# City of Albuquerque Stormwater Construction Site Inspection Report

ESC File No.	H18E070	Project Name:	McDonald's 30-0001
NPDES Id. No.	NMR1005YE	Location:	5900 Menaul Blvd NE
11/22/2023	Owner	Contractor	
Operator	McDonald's USA, LLC	Barnsley Construction	
Contact name & title	Alex Breeden	Ray Casias	
e-mail	<a href="mailto:alex.breeden@us.mcd.com">alex.breeden@us.mcd.com</a>	<a href="mailto:rayc@barnsleyconstruction.com">rayc@barnsleyconstruction.com</a>	
Contact Phone #	630-207-0289	505-856-5576	
COA Inspector	Chancellor English	Start/End Time:	1215pm
Construction Phase:	demo		
Type of Inspection:	<input type="checkbox"/> Regular	<input type="checkbox"/> Storm Event	<input type="checkbox"/> Post Storm Event >0.25" <input type="checkbox"/> 311/Complaint <input checked="" type="checkbox"/> Follow Up
Weather at time of inspection?	Clear	Temperature: ~	55
Estimated date of last storm 0.25" or greater	11/20/2023

EROSION CONTROL PLAN
C3.0

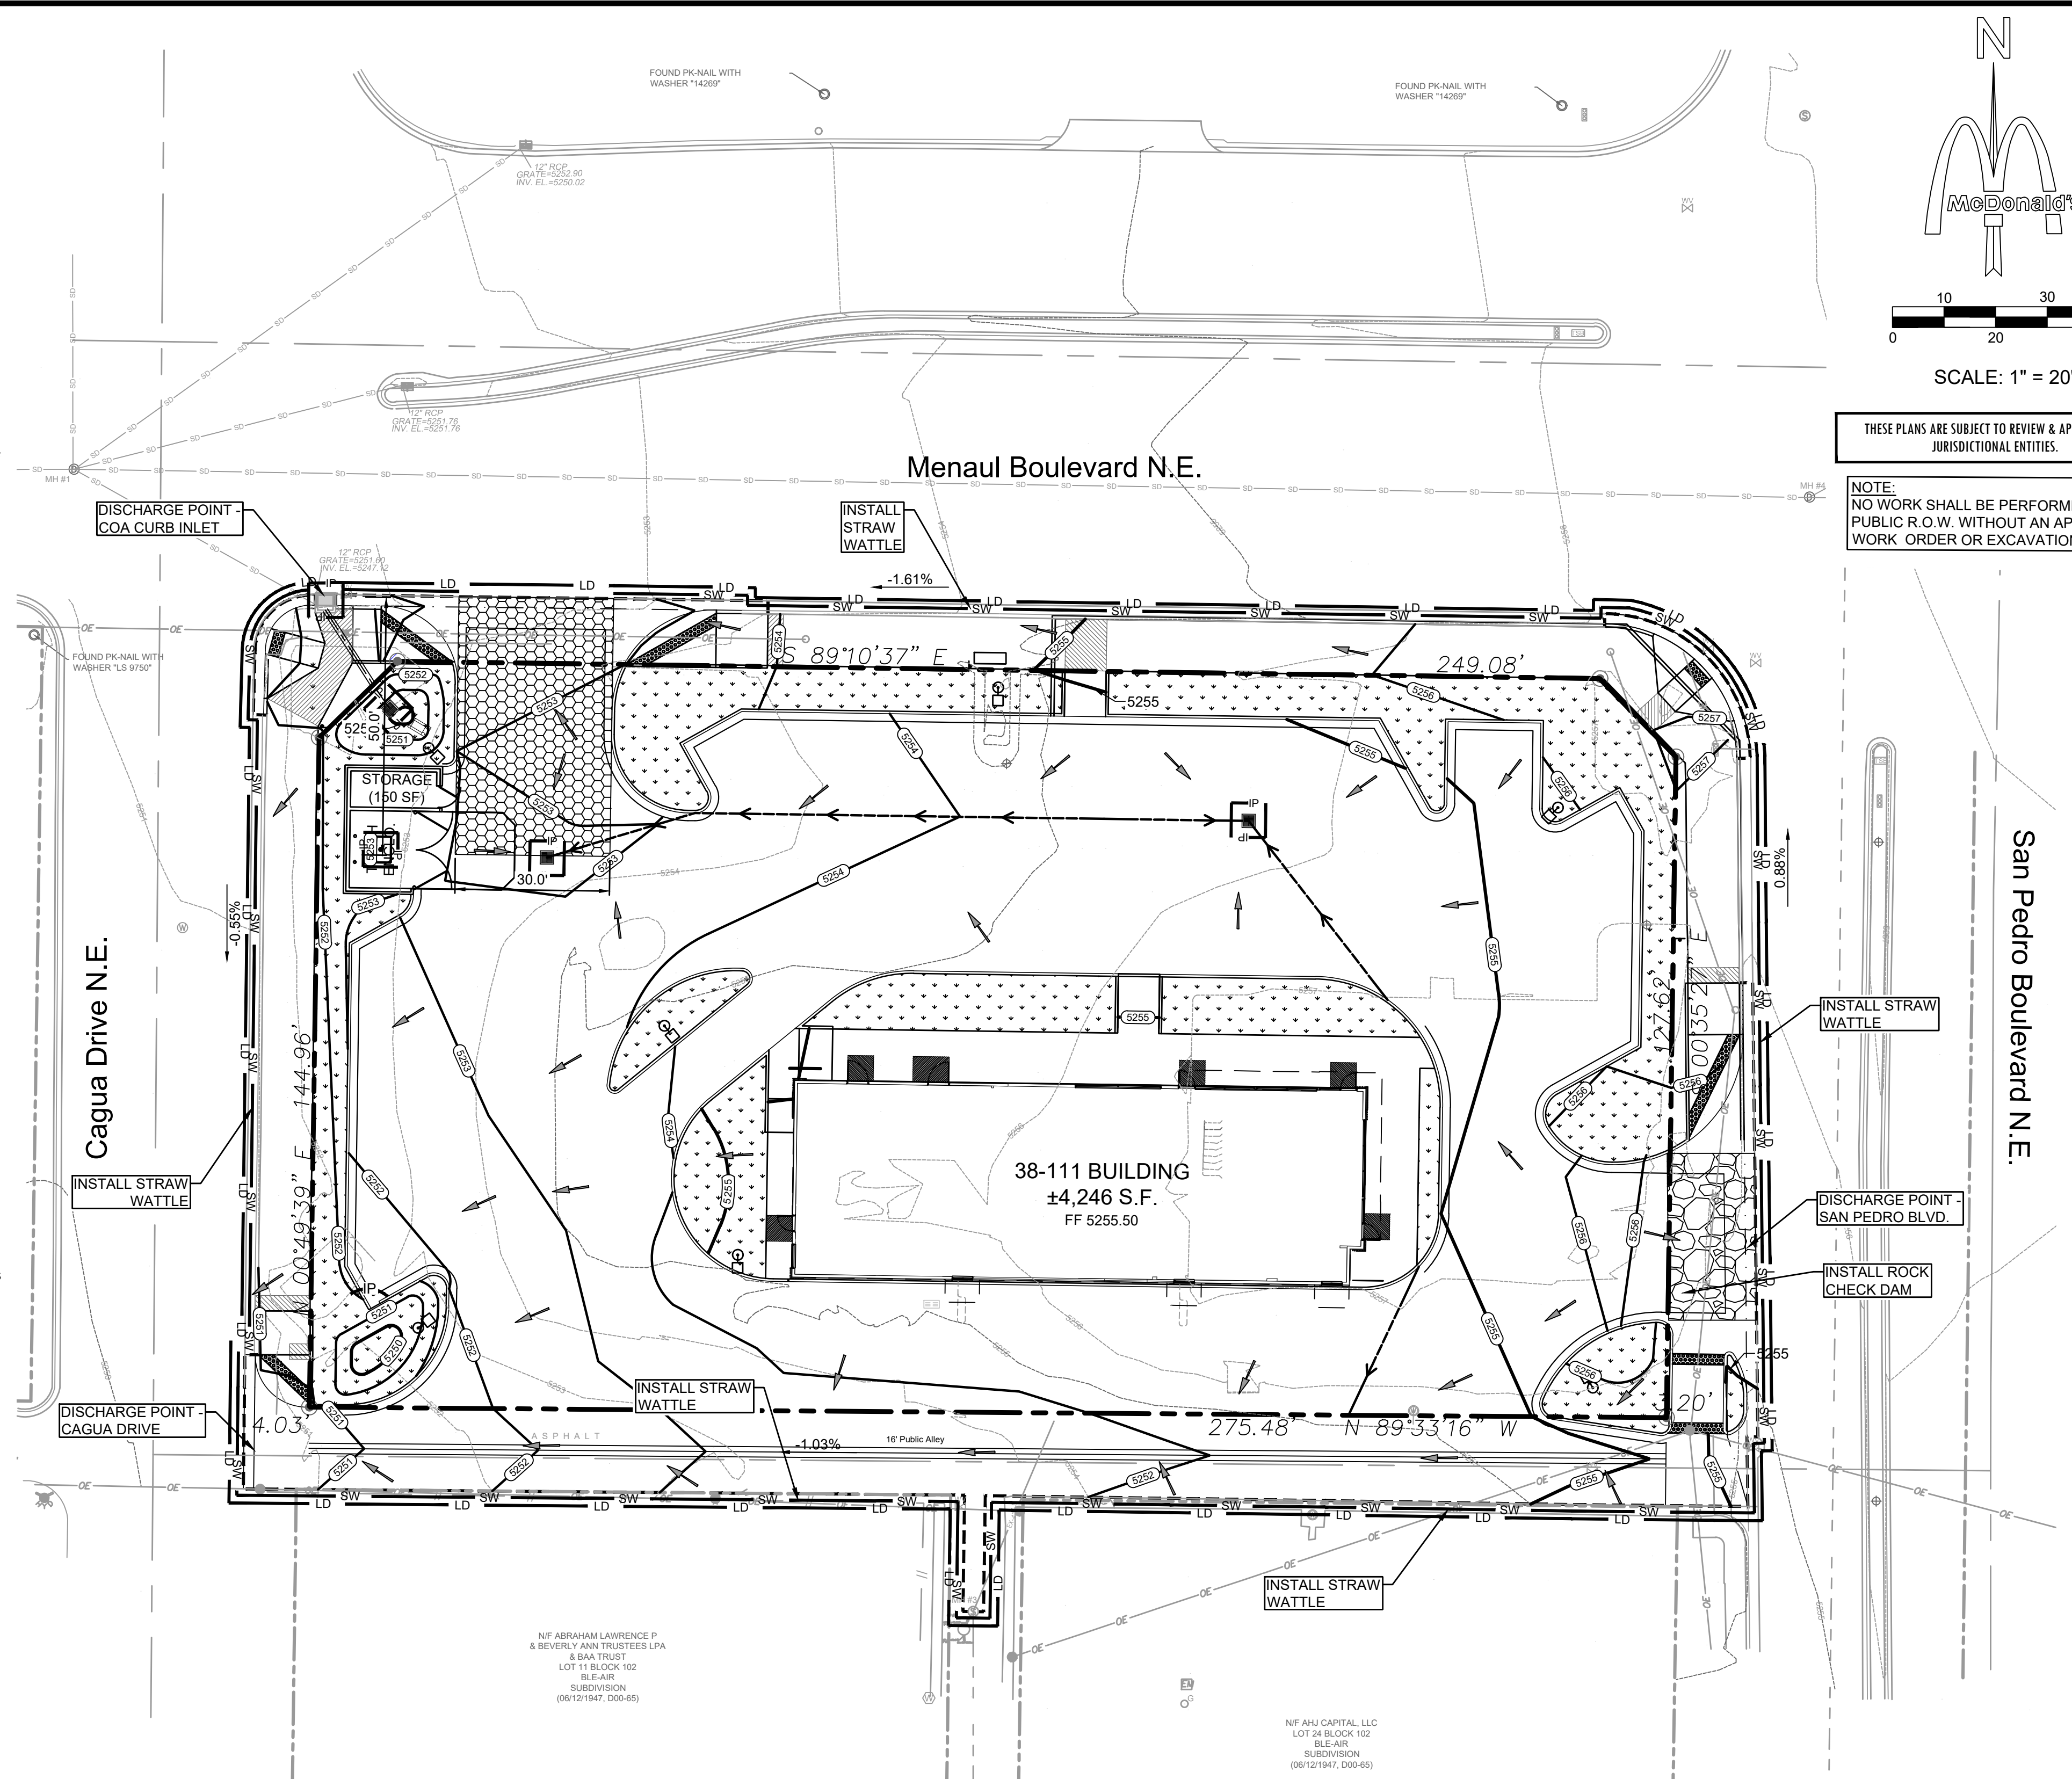
Item Number	Deficiency/ Corrective Action		
1	The SWPPP was unavailable during the inspection in violation of CGP Part 7.3. Required mitigation: You must keep a current copy of your SWPPP at the site or at an easily accessible location so that it can be made available at the time of an on-site inspection per CGP Part 7.3. Since there was no posting, there was no contact information to call and locate the SWPPP. Missing items in the electronic SWPPP sent prior to completing report. Ensure these are corrected in the on-site SWPPP: The owner needs to certify the SWPPP, Identify personnel responsible for installation and maintenance of BMPs, ensure stormwater team has required training for their responsibility, estimated phases of construction.		
2	There were gaps in the straw wattles around the perimeter of the construction site and track-out pads were not installed in violation of CGP Parts 2.1.4 and 2.2.4. Required mitigation: Ensure all stormwater controls are maintained and remain in effective operating condition during permit coverage and are protected from activities that would reduce their effectiveness, per CGP Part 2.1.4. Minimize sediment track-out and implement track-out controls as necessary to ensure sediment removal occurs prior to vehicle exit per CGP Part 2.2.4.
